EL PASO COUNTY STORMWATER MANAGEMENT PLAN CHECKLIST

EPC Project Number: Pending

GRADING & EROSION CONTROL PLAN
INTERIM AND VERTICAL PHASES

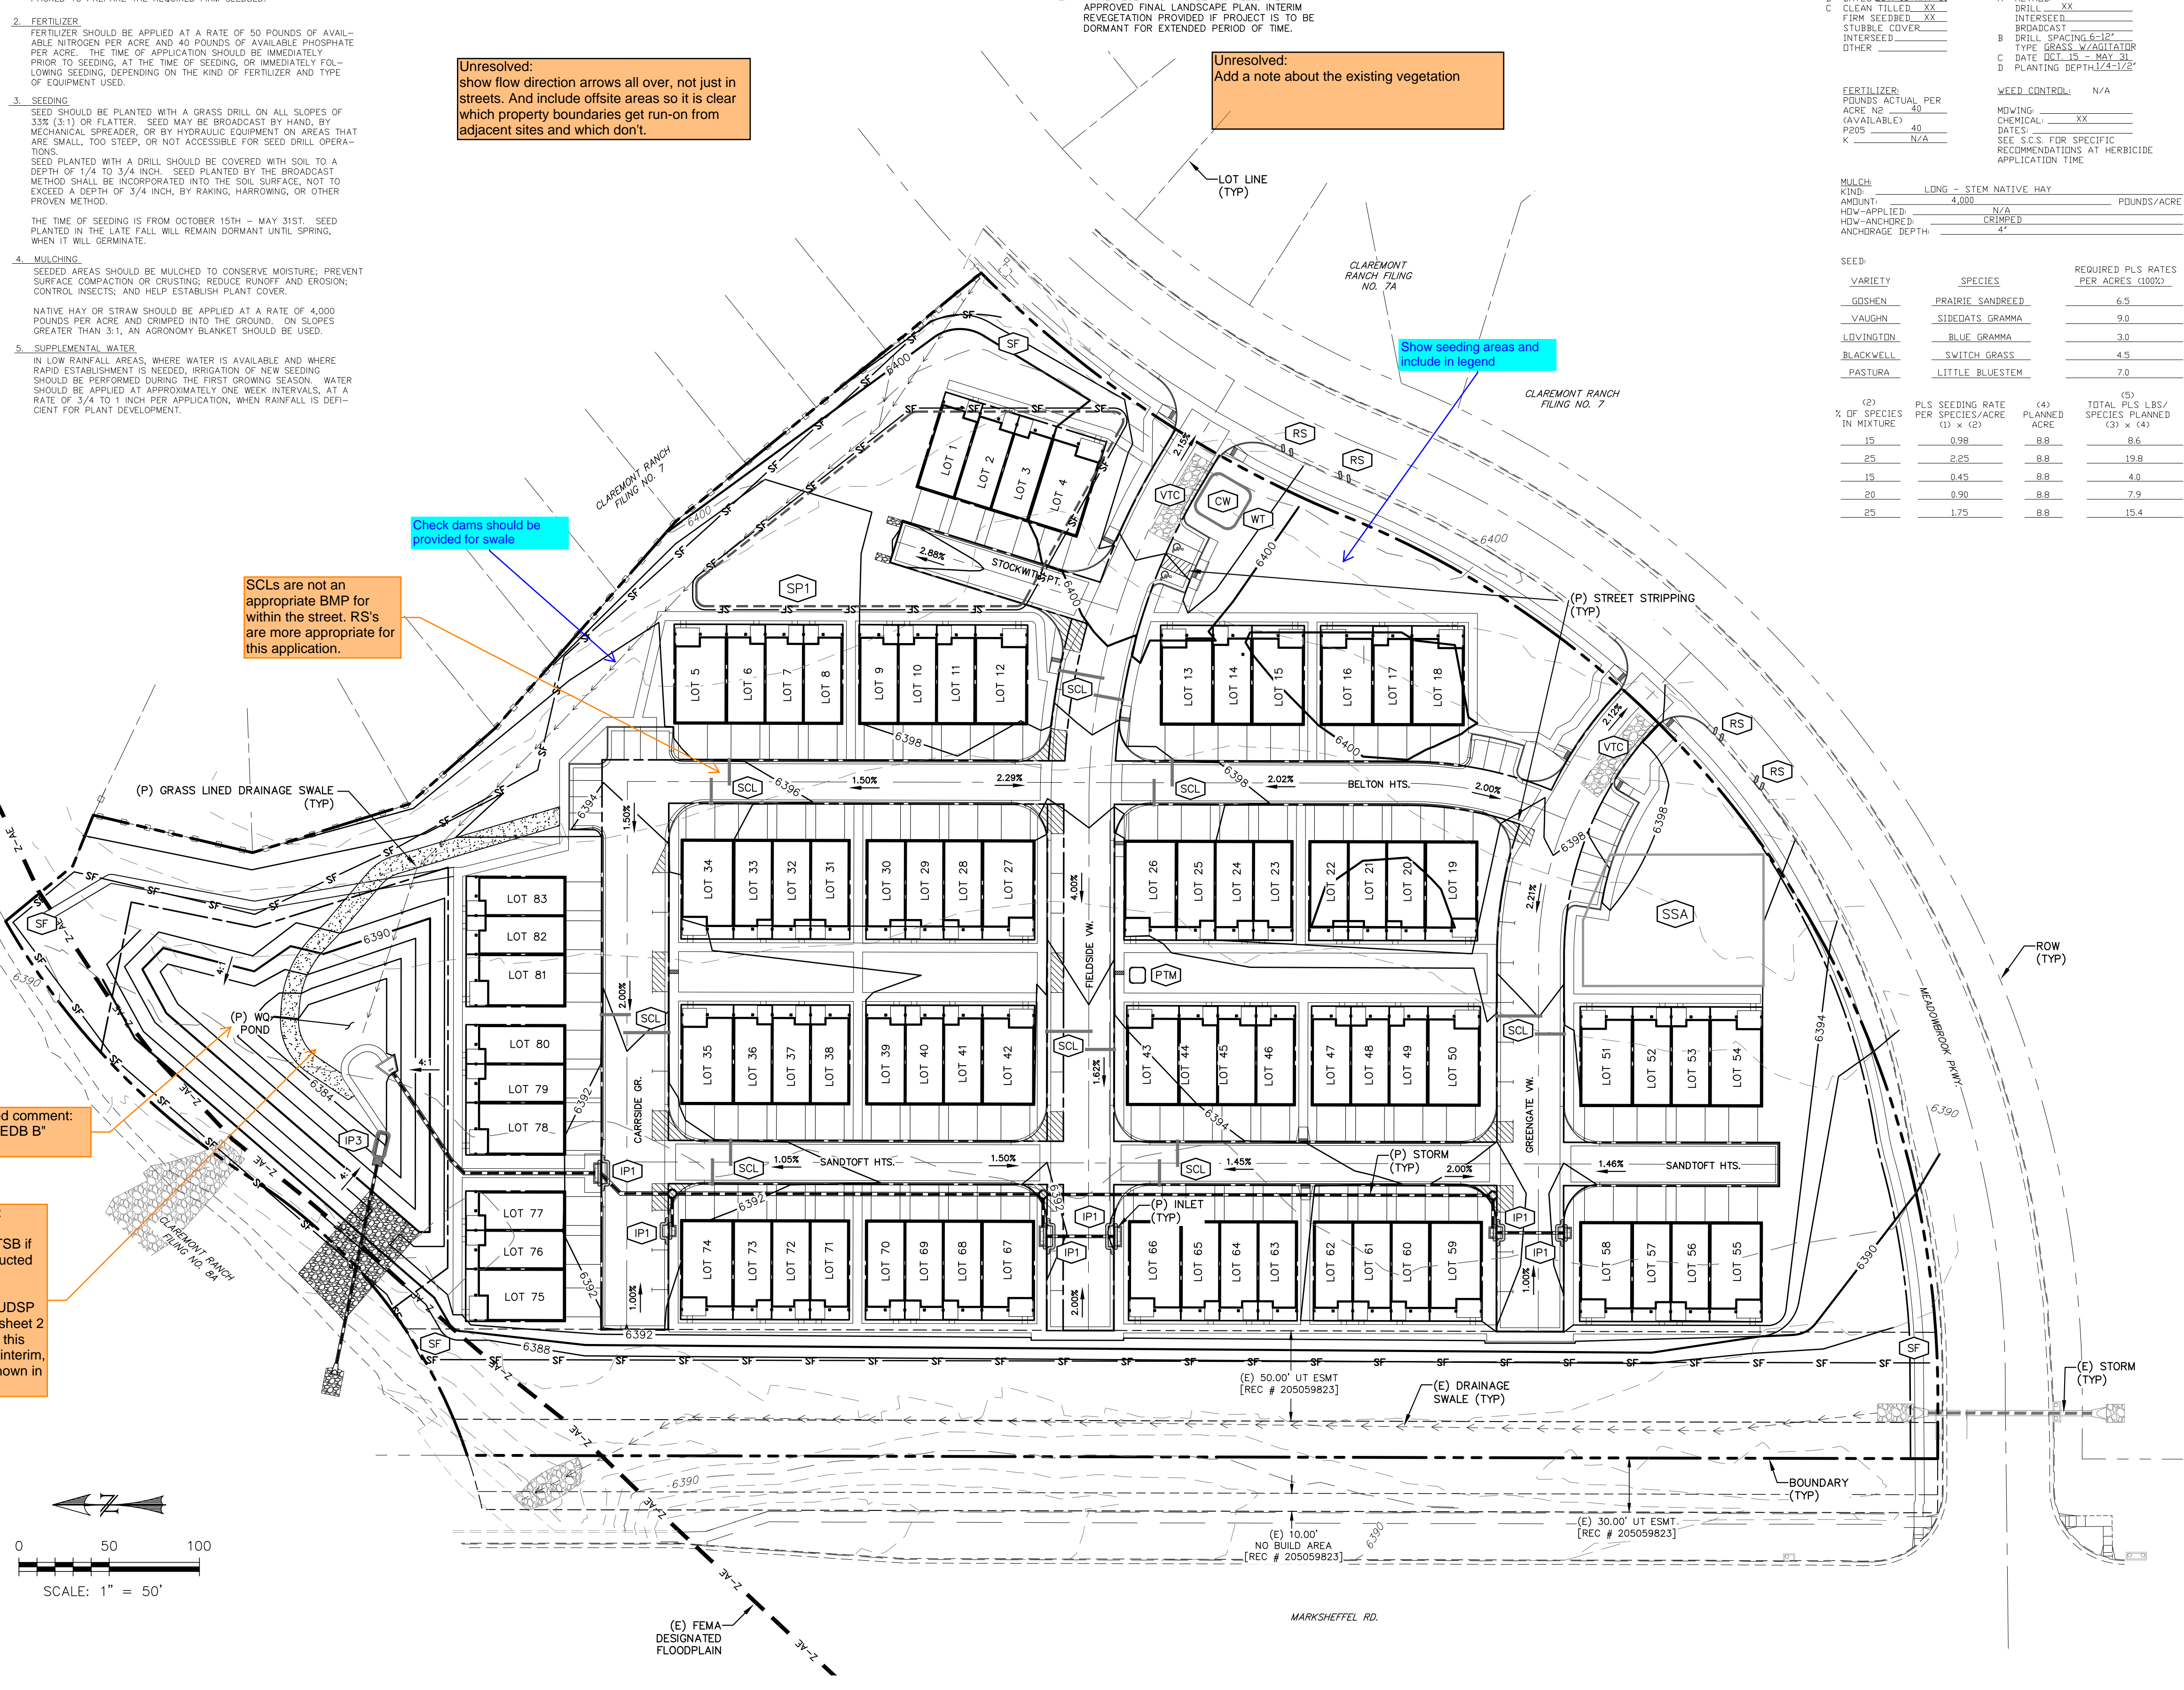
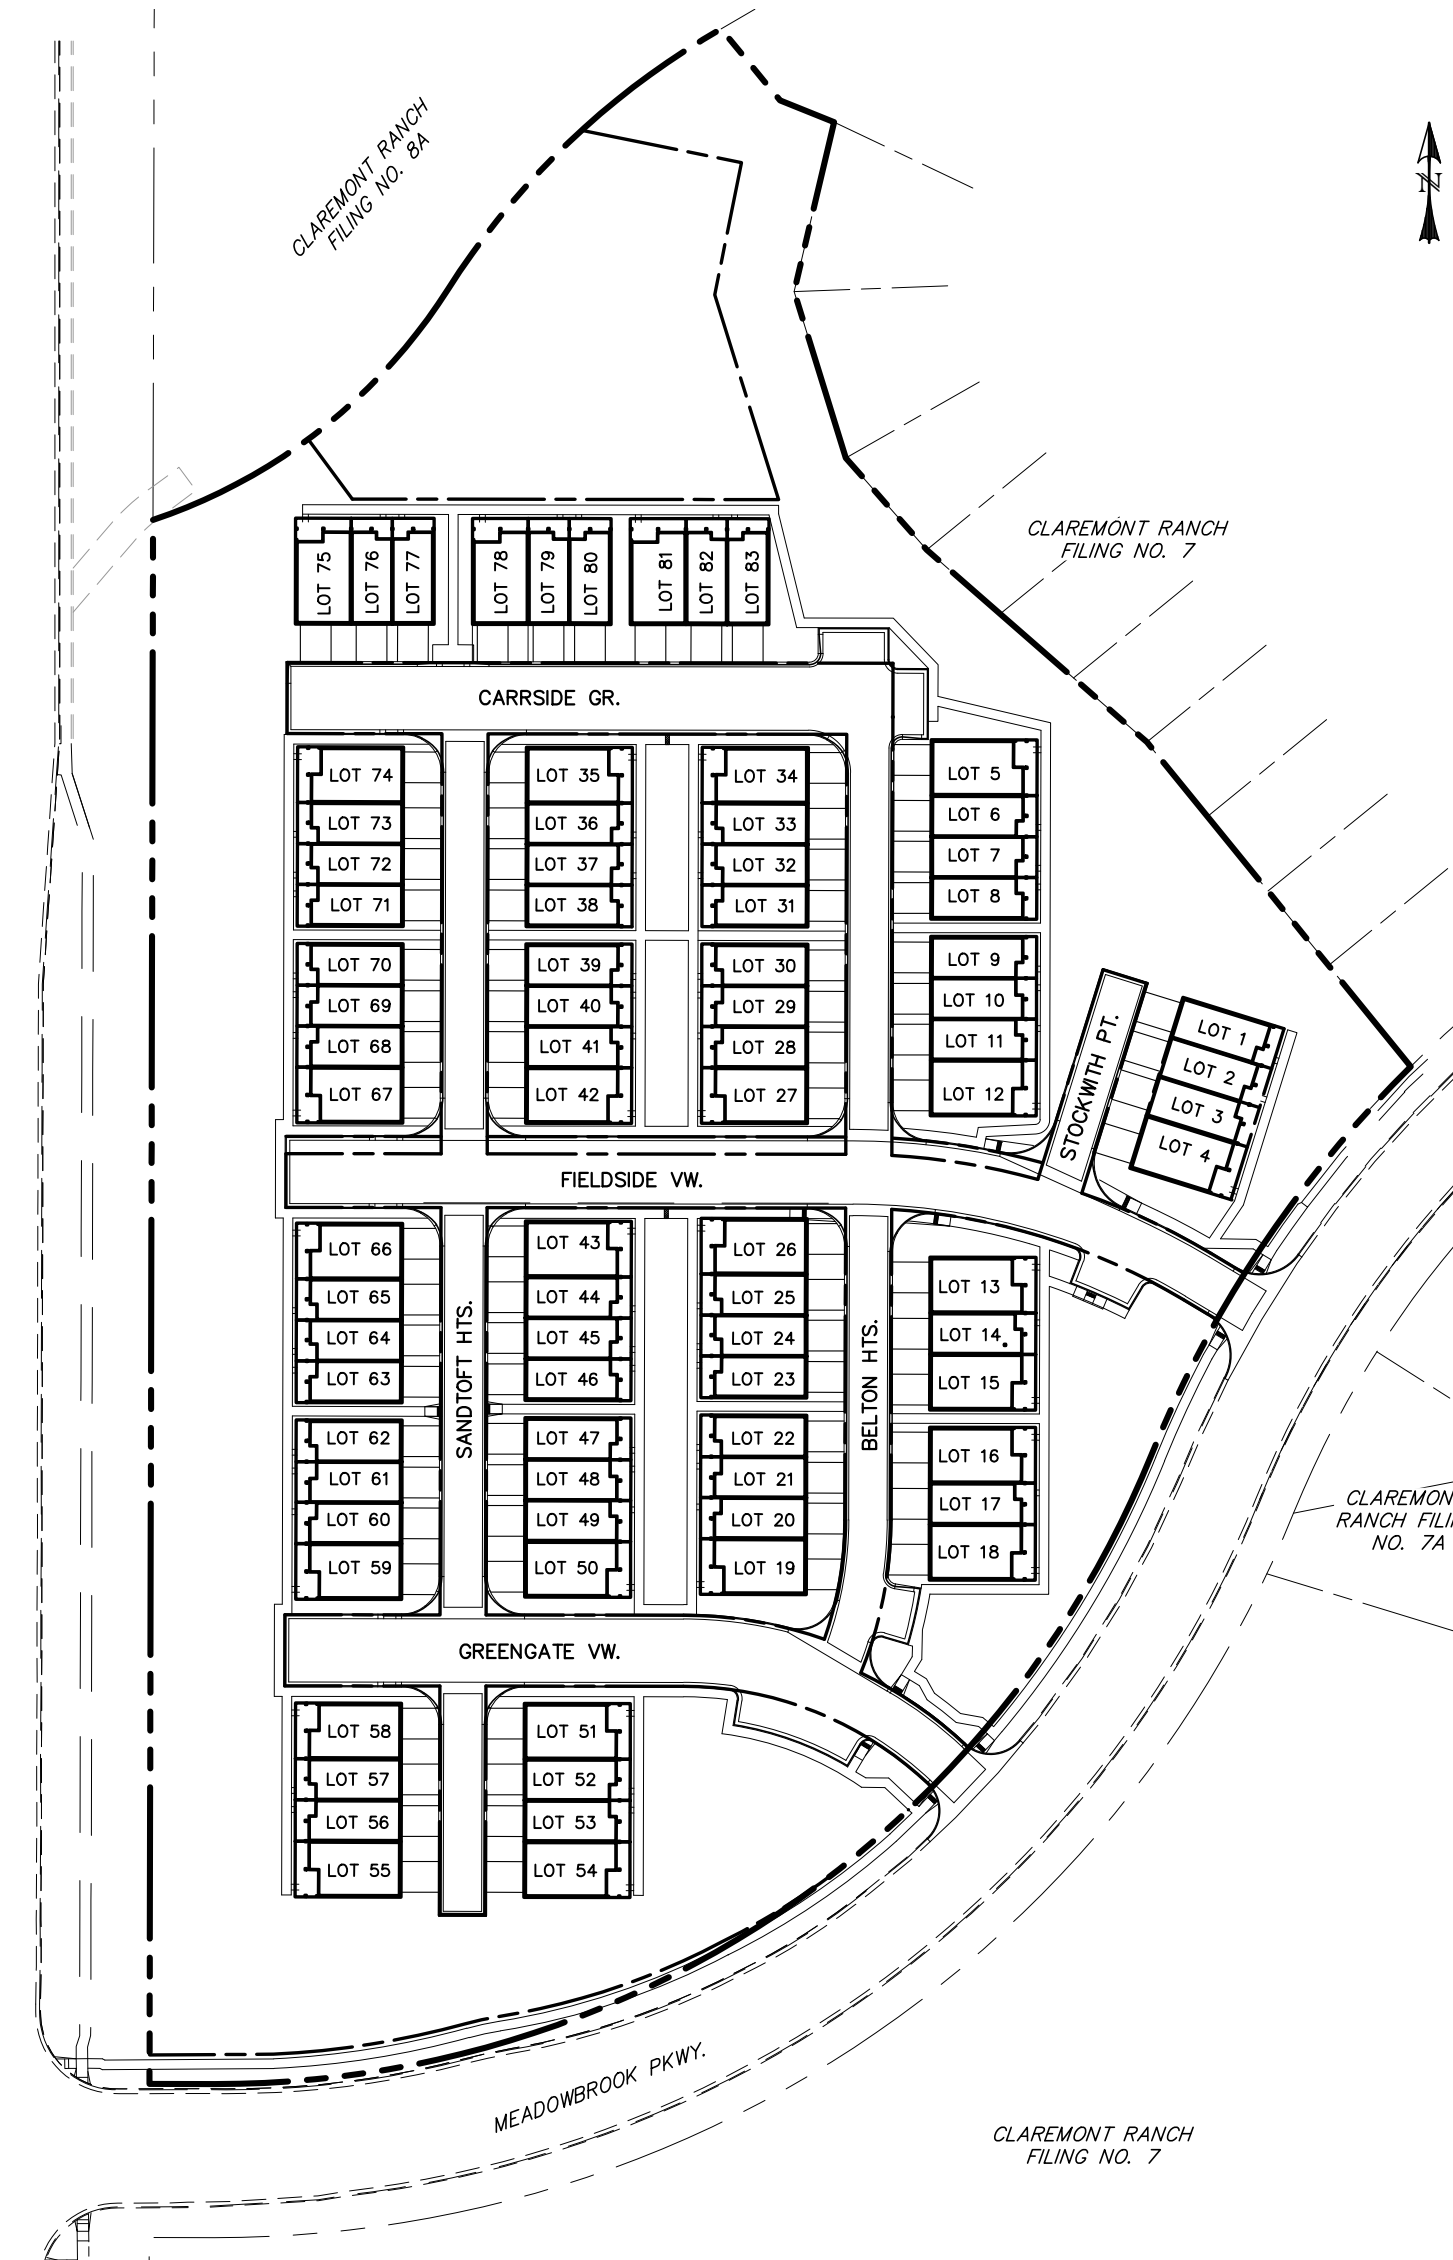
I'm still not seeing either item on the plans. Item 17c is on the Legend of Sht1, but not on plans. Item 17d is not seen on Legend or plans

Applicant	EPC
17	SWMP Map to include:		
17a	construction site boundaries		Y
17b	flow arrows to depict stormwater flow directions		Y
17c	all areas of disturbance Please note Legend and delineated limits.		N
17d	areas of cut and fill Please note Legend and delineated limits.		N
17e	areas used for storage of building materials, soils (stockpiles) or wastes		Y
17f	location of any dedicated asphalt / concrete batch plants		Y
17g	location of all structural control measures		Y
17h	location of all non-structural control measures		Y
17i	springs, streams, wetlands and other surface waters, including areas that require maintenance of pre-existing vegetation within 50 feet of a receiving water		Y
18	Narrative description of all structural control measures to be used. Modifications to EPC standard control measures must meet or exceed County-approved details		Y
19	Description of all non-structural control measures to be used including seeding, mulching, protection of existing vegetation, site watering, sod placement, etc.		Y
